# **Application by Springwell Energy Farm Ltd for an order granted development consent for the Springwell Solar Farm**

## **Written Representation**

**A report prepared by North Kesteven District Council  
(ID 20054501)**

**Planning Inspectorate reference: EN01049**

TITLE:
FIGURE 3.11B
VEGETATION REMOVAL PARAMETERS
SPRINGWELL EAST

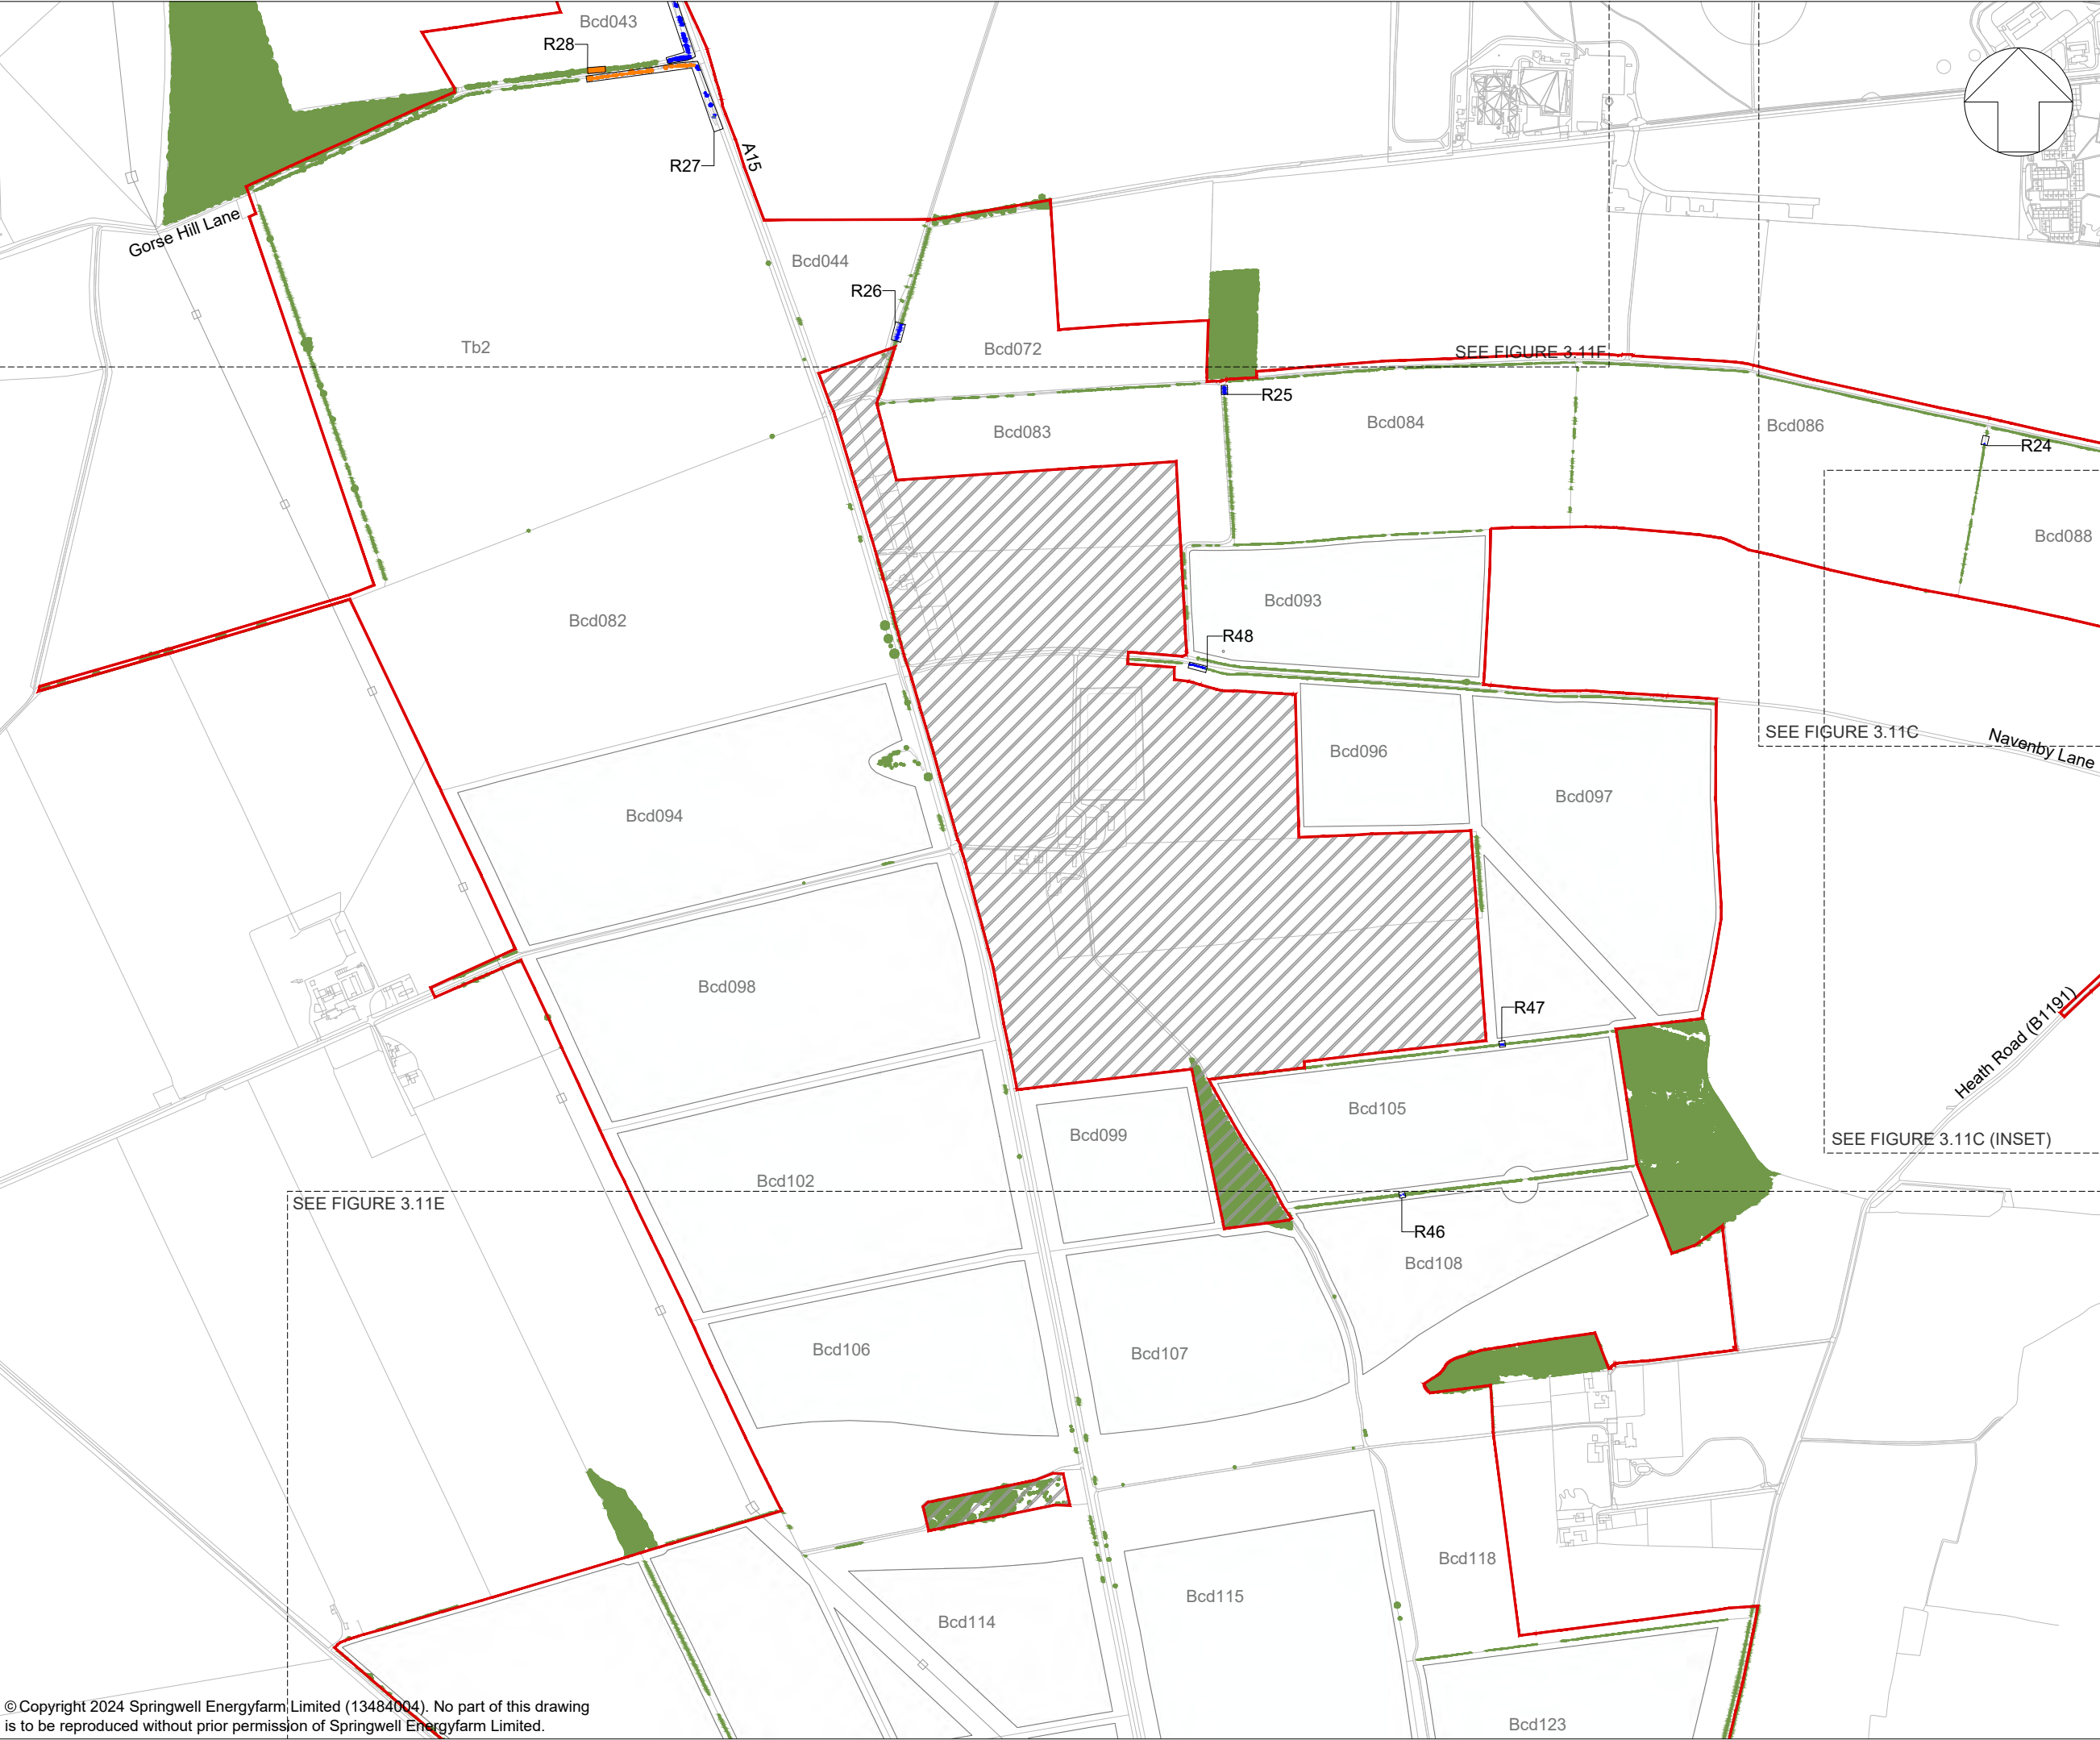
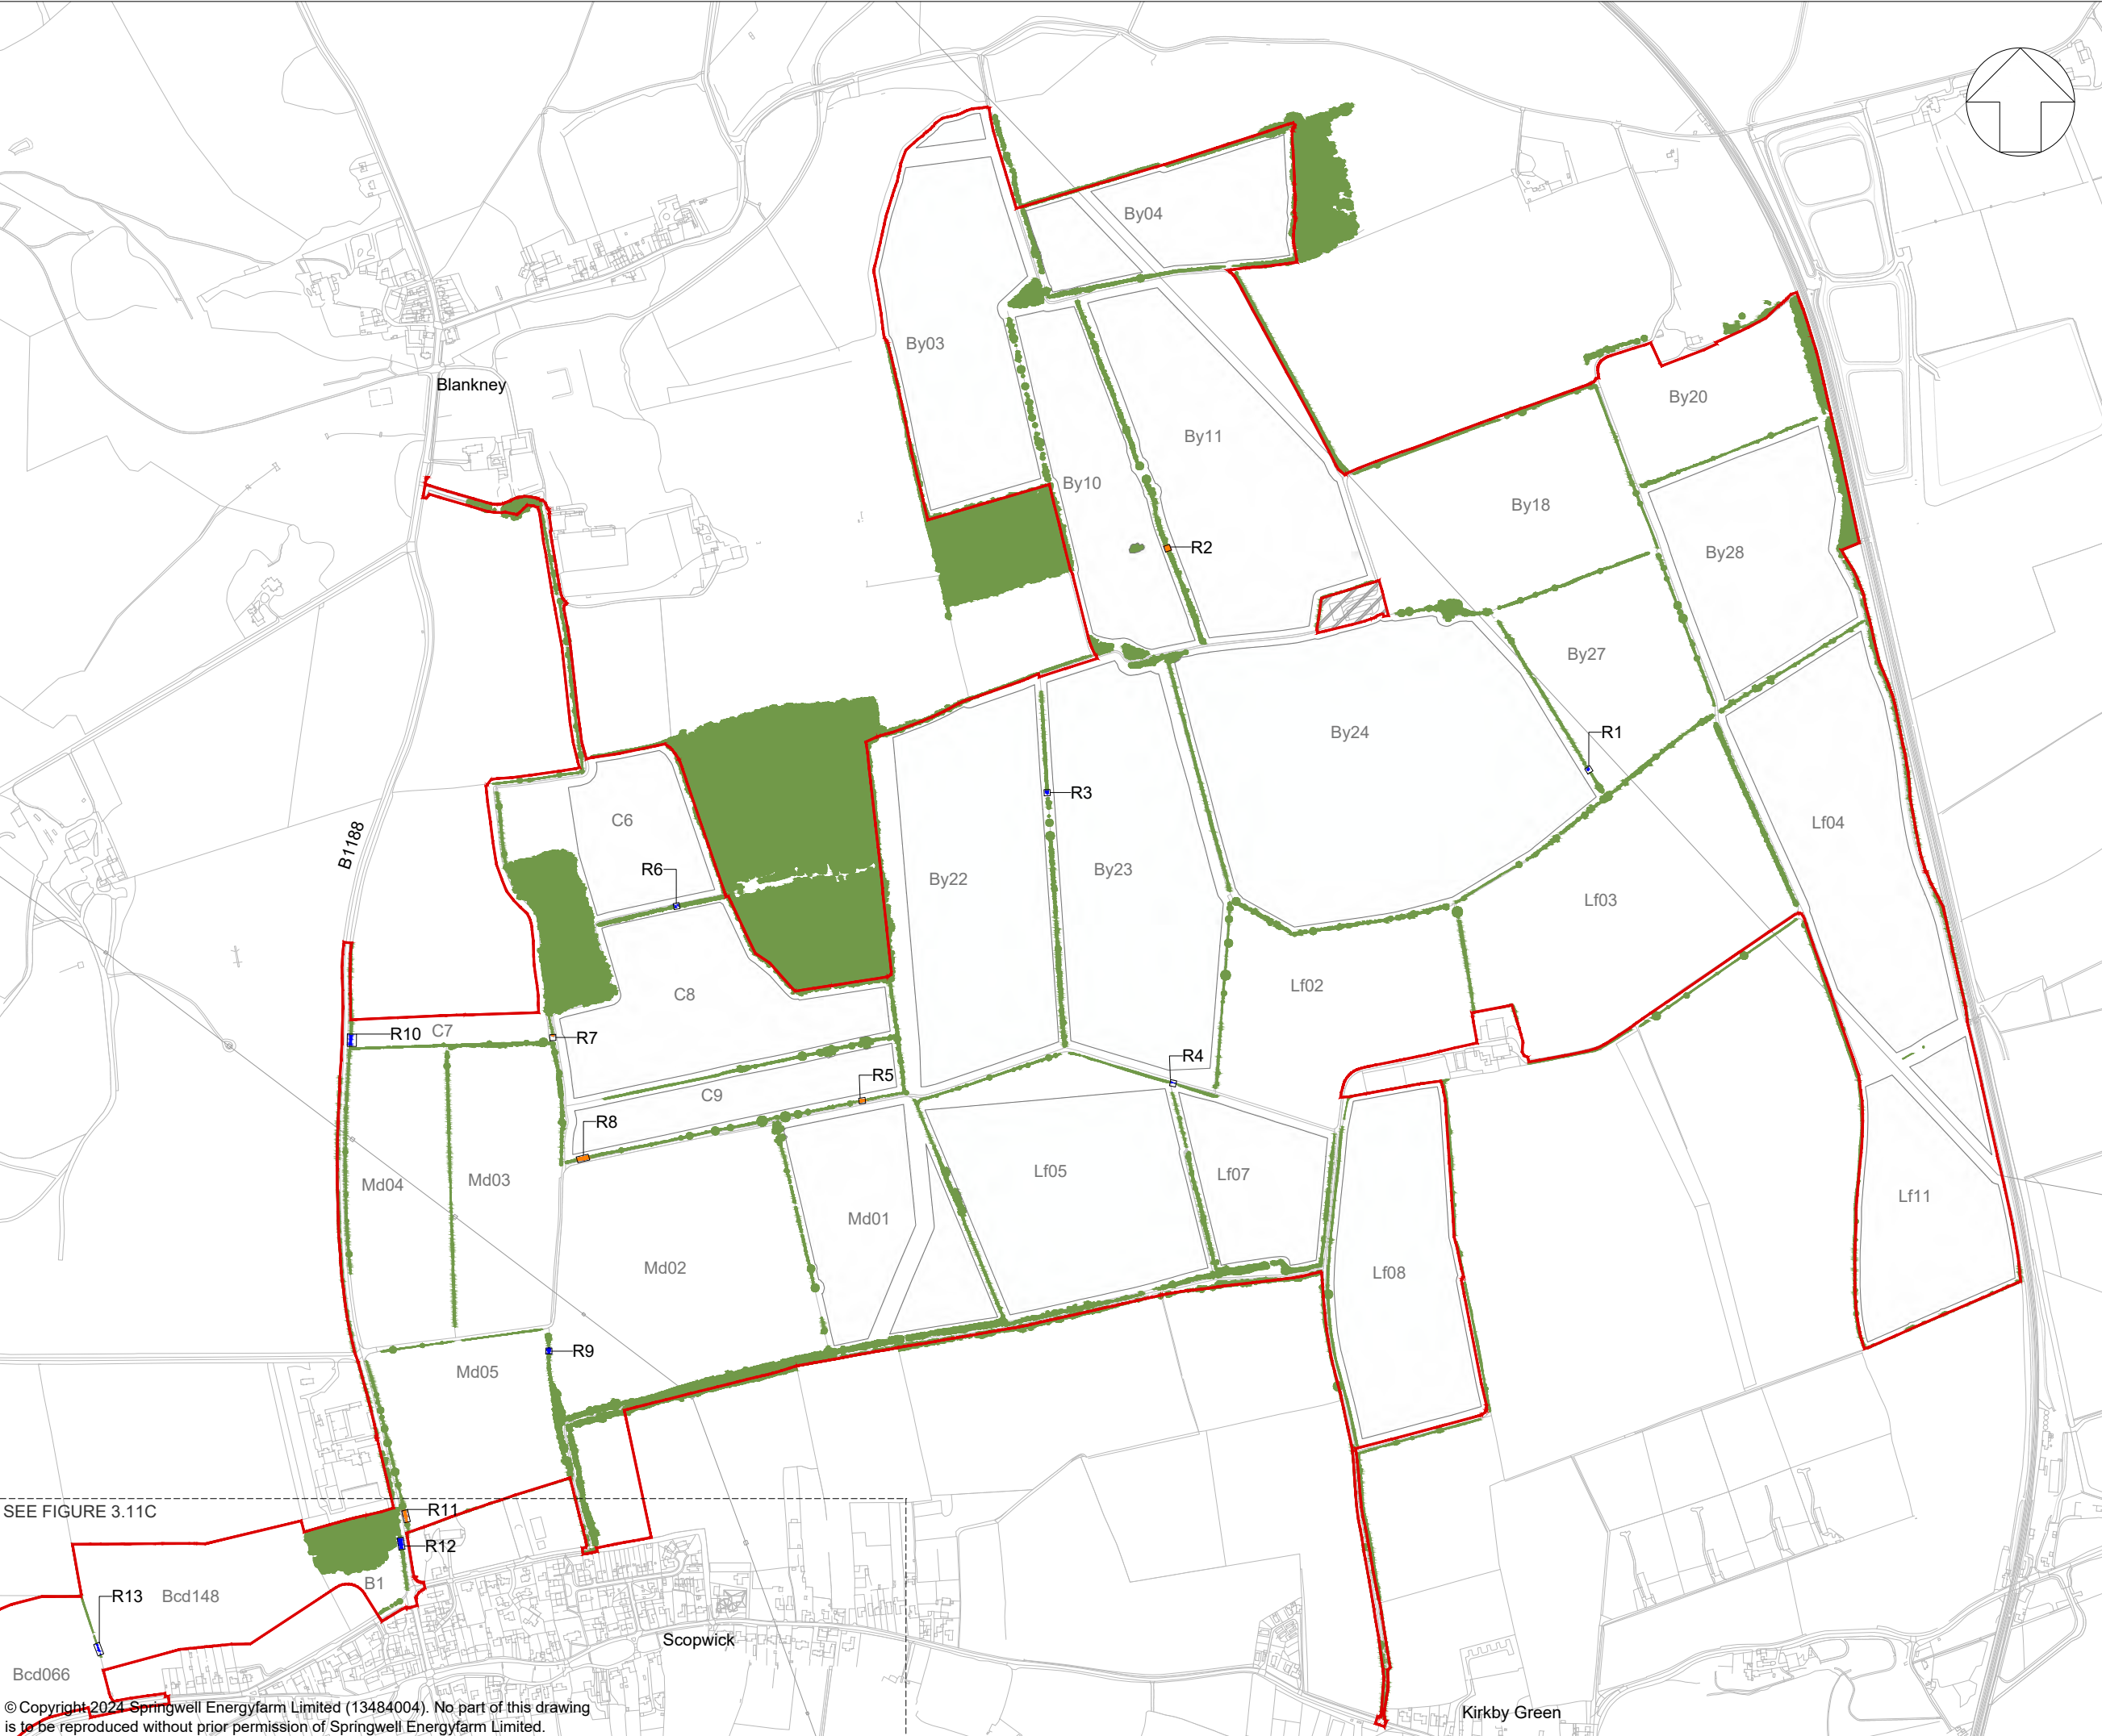
- 5.6 In addition, AAH recommend that vegetation removal is limited along site boundaries or sight lines, or along construction access routes, due to its potential to change the character of the local landscape beyond the limits of the development. Tree and vegetation removal must be clarified through the examination process, and subsequently any works or removal of trees and hedgerows must be agreed prior to any works commencing.
